## 31 Fore Street - Final Traffic Comments

Jean – The following represents a status update of my preliminary review and represents my final comments.

### 3. Construction Management Plan

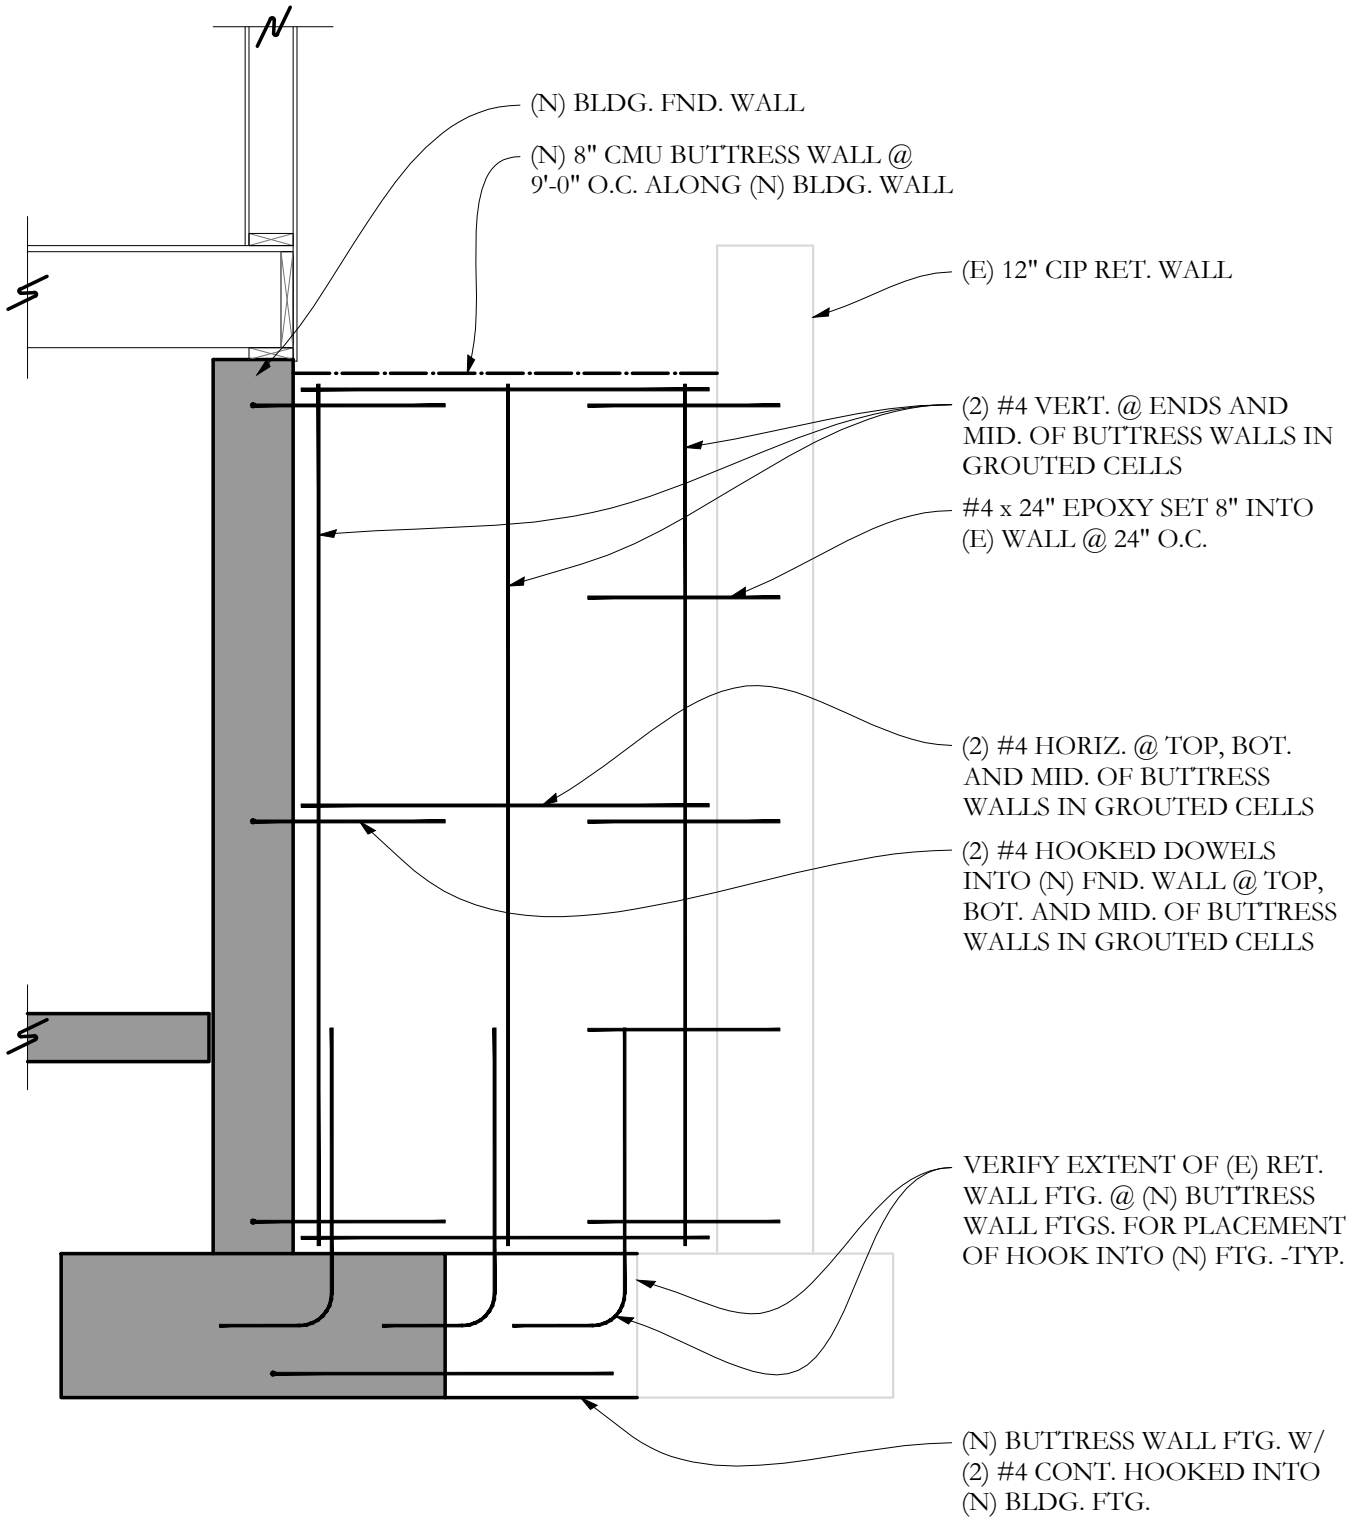
- The applicant shall provide a construction management plan for review and approval.

**Status: Additional detail on the construction plan is required, particularly as it relates to potential sidewalk closures and contractor parking. I suggest that this be a condition of approval with a plan being submitted for review and approval prior to issuance of any City permits.**

DRAWING NO.  
**C-10**

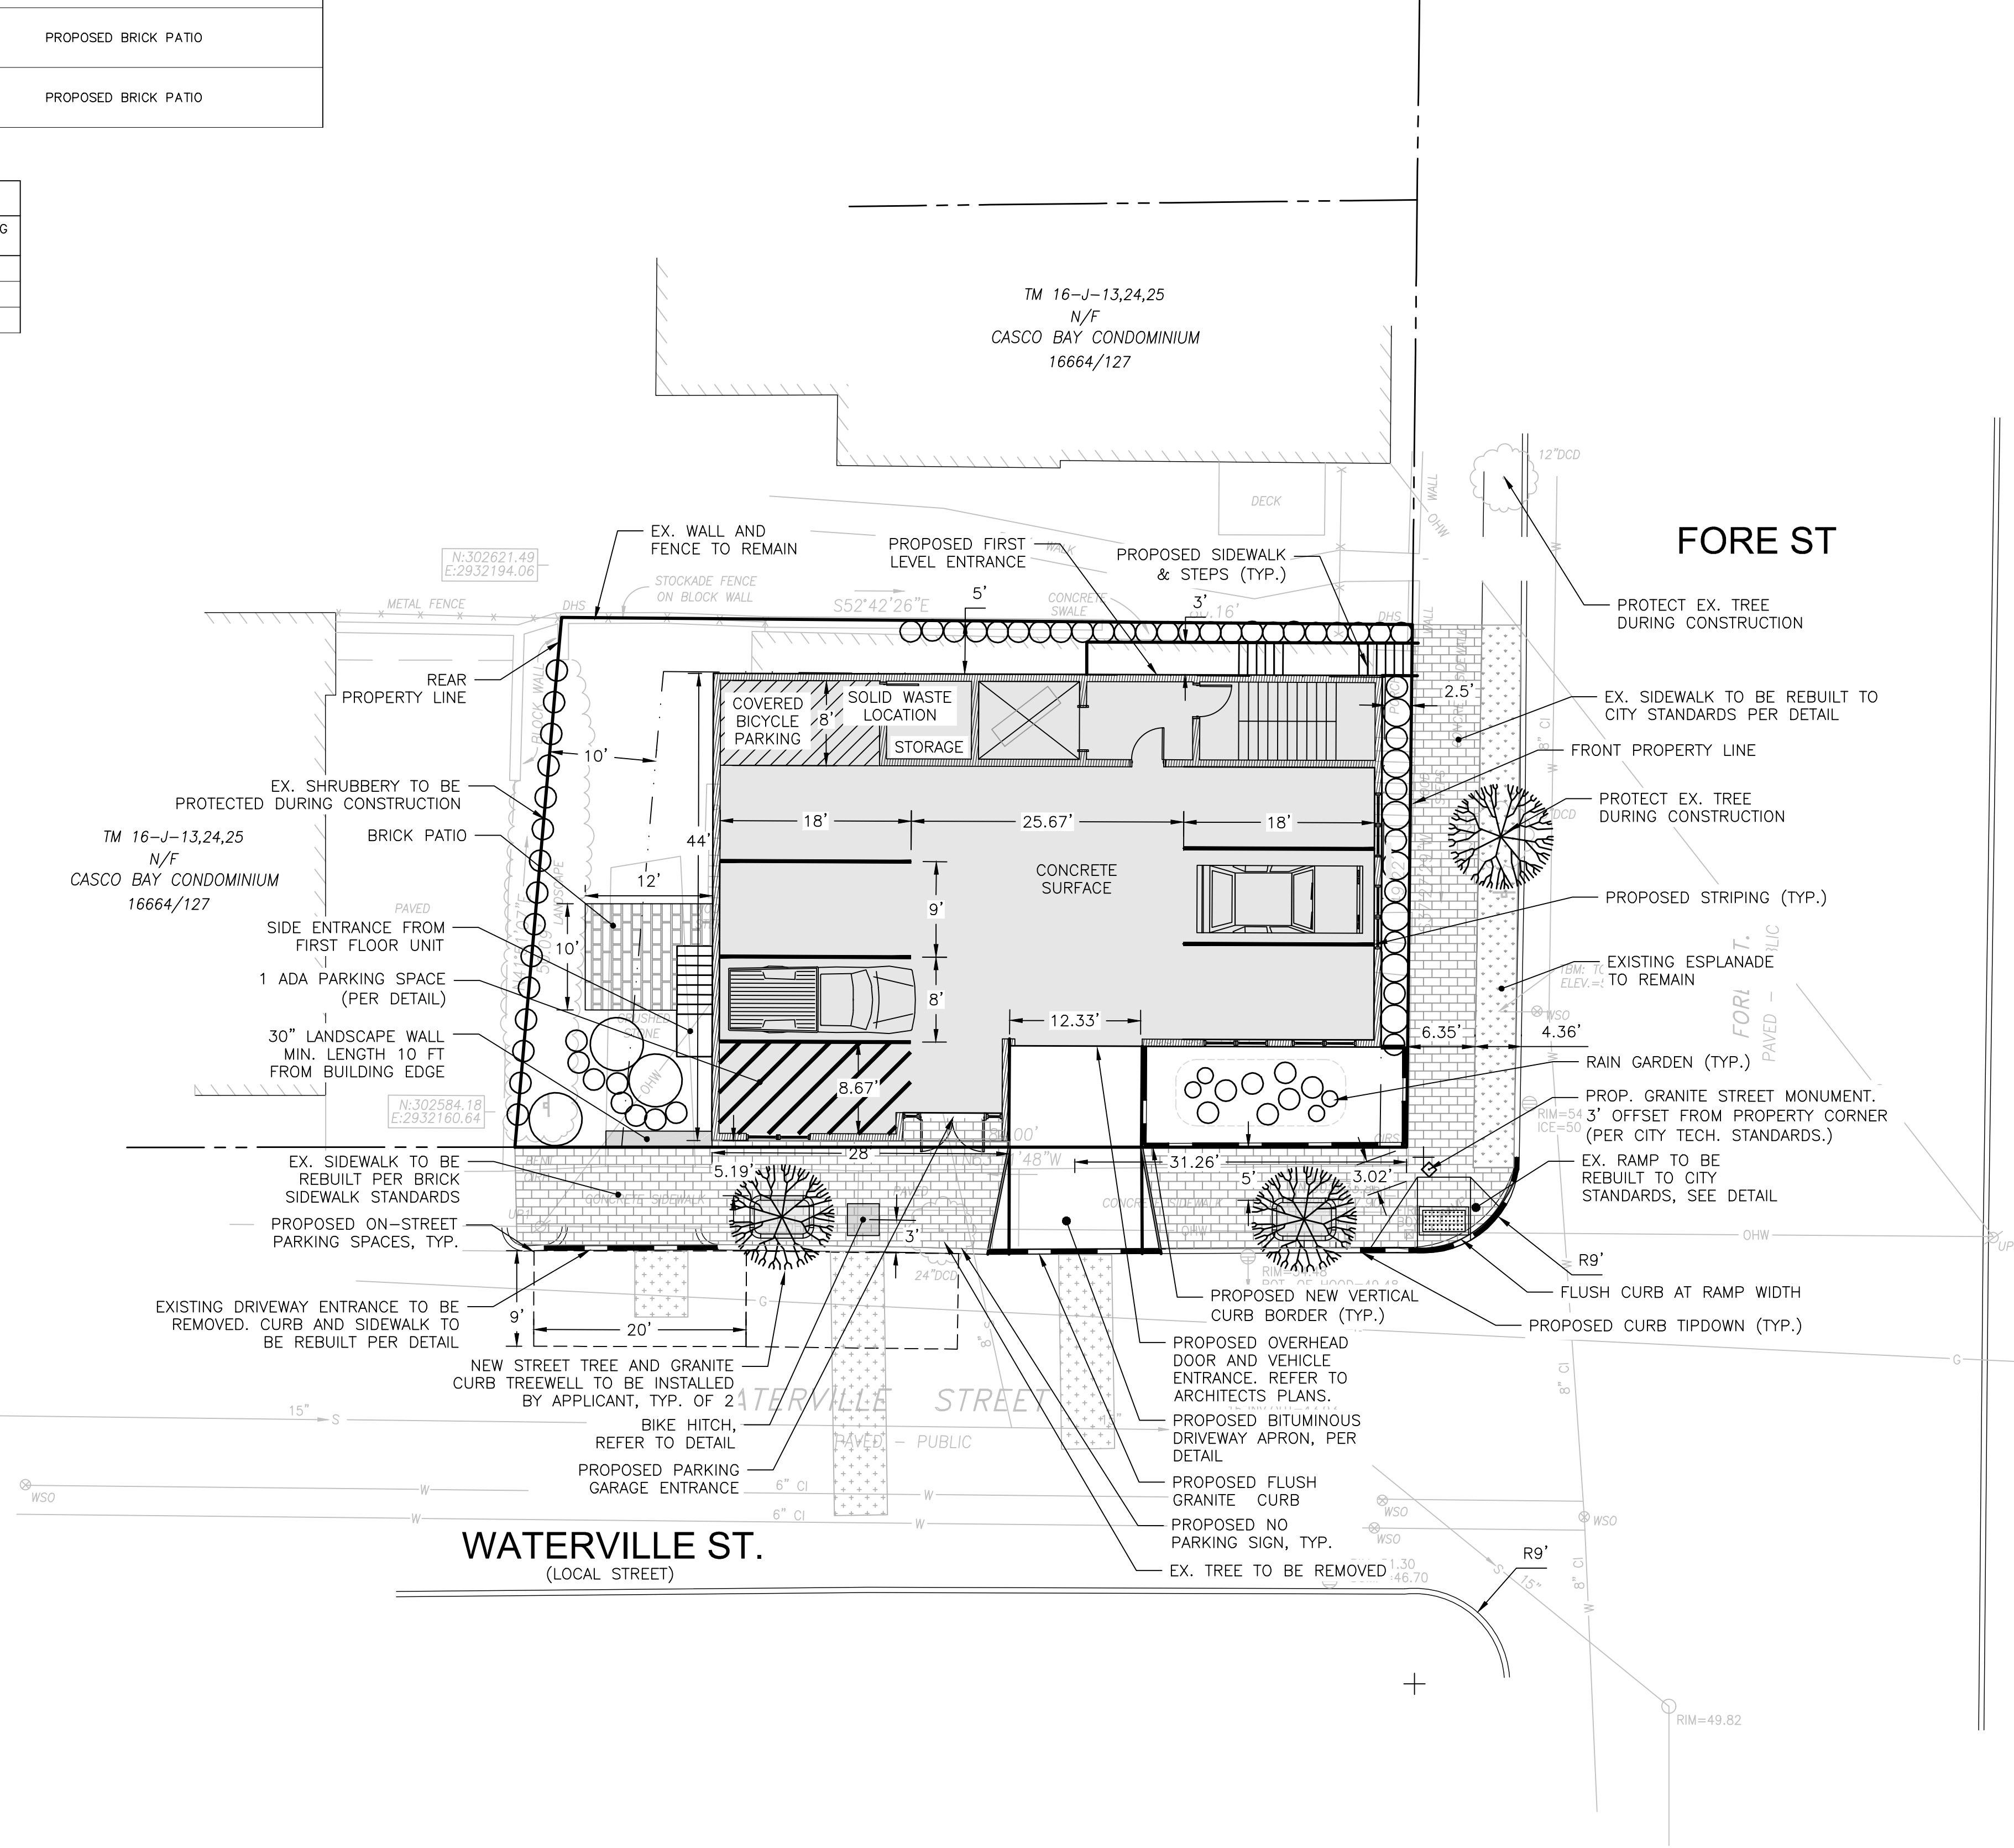
- The proposed project does not meet City standards as it relates to corner clearance. City standards require 35 feet of clearance, and the project will be providing approximately 31 feet of clearance. Given that the project is providing a driveway on the lower volume street (not on Fore Street), providing increased separation with a nearby driveway, and site design factors, I find the driveway location to be acceptable and I support a waiver from City standards.

- The aisle width for the parking lot is slightly wider than City standards. I support a waiver from City standards.

**Status: I continue to support a waiver given site conditions.**

**Status: I have no further comment.**
